**Subject: Sterling Ranch Phase II Preliminary Plan (SP-203)**

The Planning Division of the Community Services Department has reviewed the Sterling Ranch Phase II Preliminary Plan, and has the following comments of behalf of El Paso County Parks. This application will be presented to the Park Advisory Board September 9, 2020.

COVER SHEET

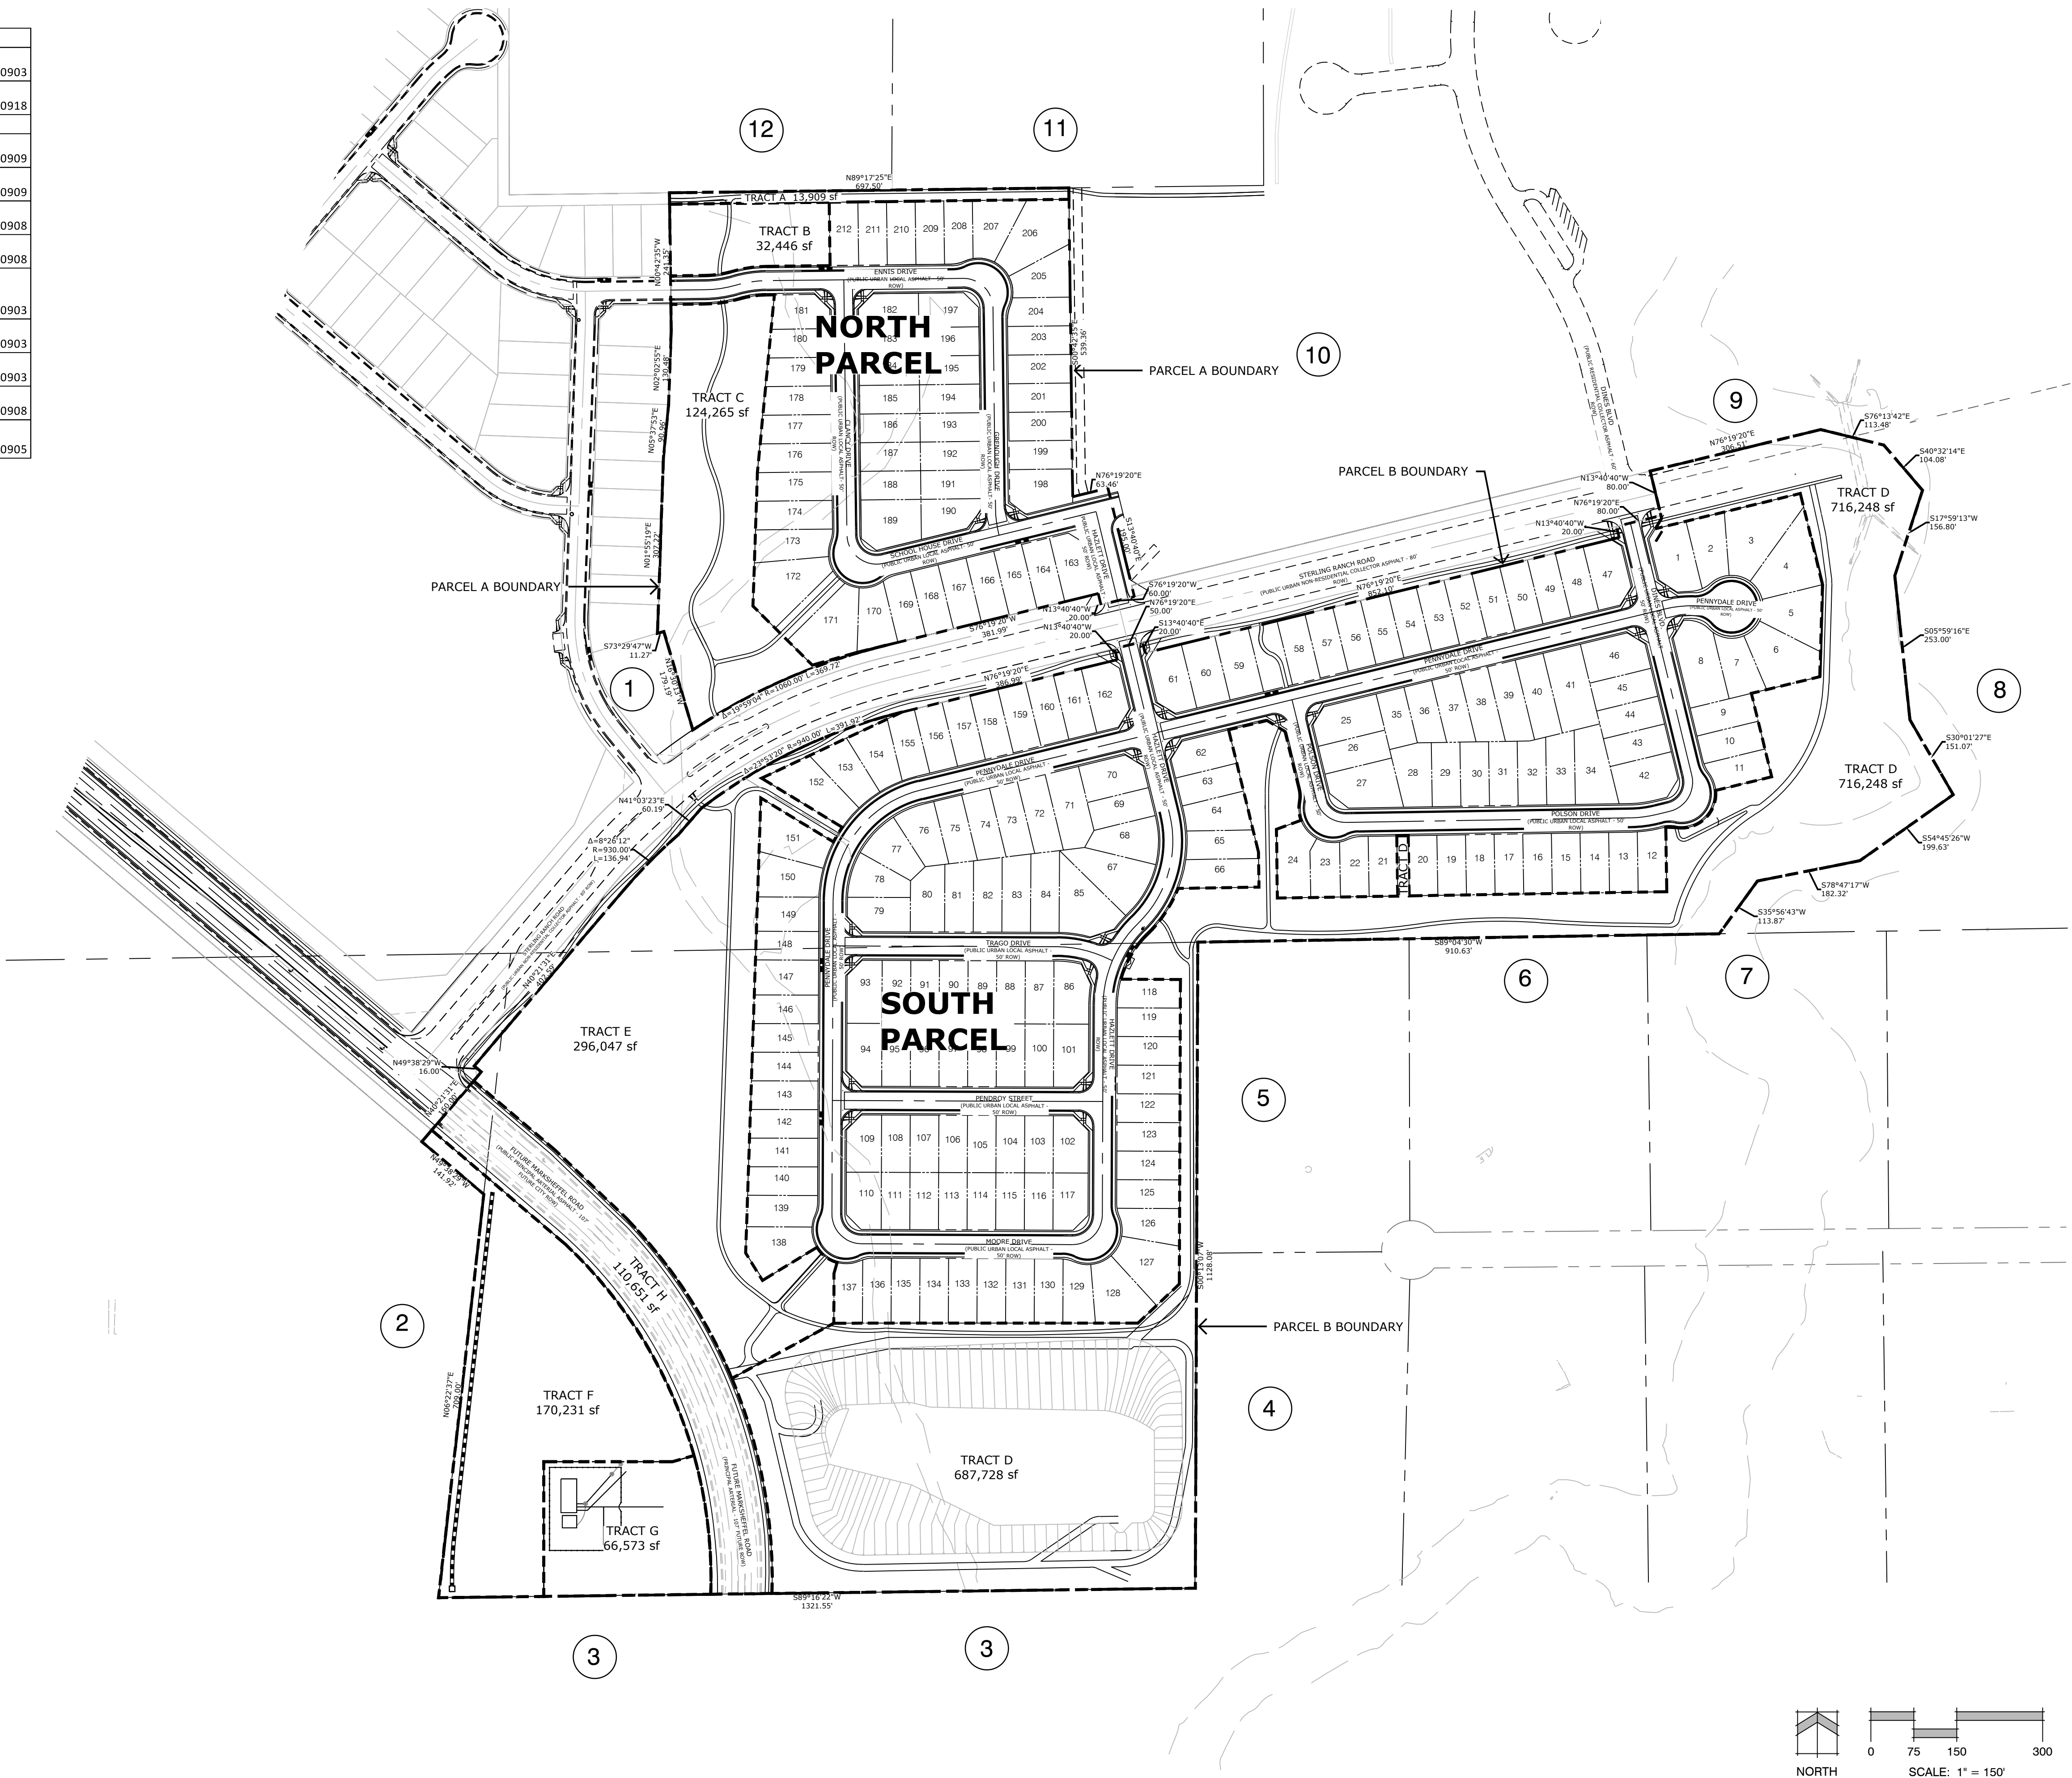
The Preliminary Plan includes an interconnected system of trails and open space. Including open space along the Sand Creek and a connection to the proposed Sand Creek Regional Trail. Sidewalks along Sterling Ranch Road will also provide a connection to the western branch of the Sand Creek Trail, along Marksheffel Road.

Staff recommends that the developers designate and provide to El Paso County 25-foot trail easements along the Phase II section of Sand Creek that allows for public access, as well as construction and maintenance of the Sand Creek Regional Trail. Furthermore, staff recommends that the developers dedicate to El Paso County a 25-foot wide trail easement along Sterling Ranch Road for public access, construction and maintenance of the west section of the Sand Creek Regional Trail. Lastly, staff recommends fees in lieu of land dedication for regional and urban park purposes on all forthcoming final plats.

*Recommend to the Planning Commission and the Board of County Commissioners that approval of Sterling Ranch Phase II Preliminary Plan includes the following conditions: (1) show on the Final Plat and dedicate to El Paso County a 25-foot trail easement along the west side of Sand Creek that allows for public access, as well as construction and maintenance of the Sand Creek Regional Trail; (2) show on the Final Plat and dedicate to El Paso County a 25-foot trail easement along the north side of Marksheffel Road that allows for public access, as well as maintenance by El Paso County of the western branch of the Sand Creek Primary Regional Trail; (3) recommend the developer dedicate to El Paso County a 25-foot wide trail easement along Sterling Ranch Road for public access, construction and maintenance of the west section of the Sand Creek Regional Trail; (4) fees in lieu of land dedication for regional park purposes in the total amount of \$99,004 and urban park fees in the total amount of \$62,540 will be required on all forthcoming Final Plat(s). A park lands agreement may be an acceptable alternative to urban park fees provided the agreement is approved by the County and executed prior to recording the final plat.*
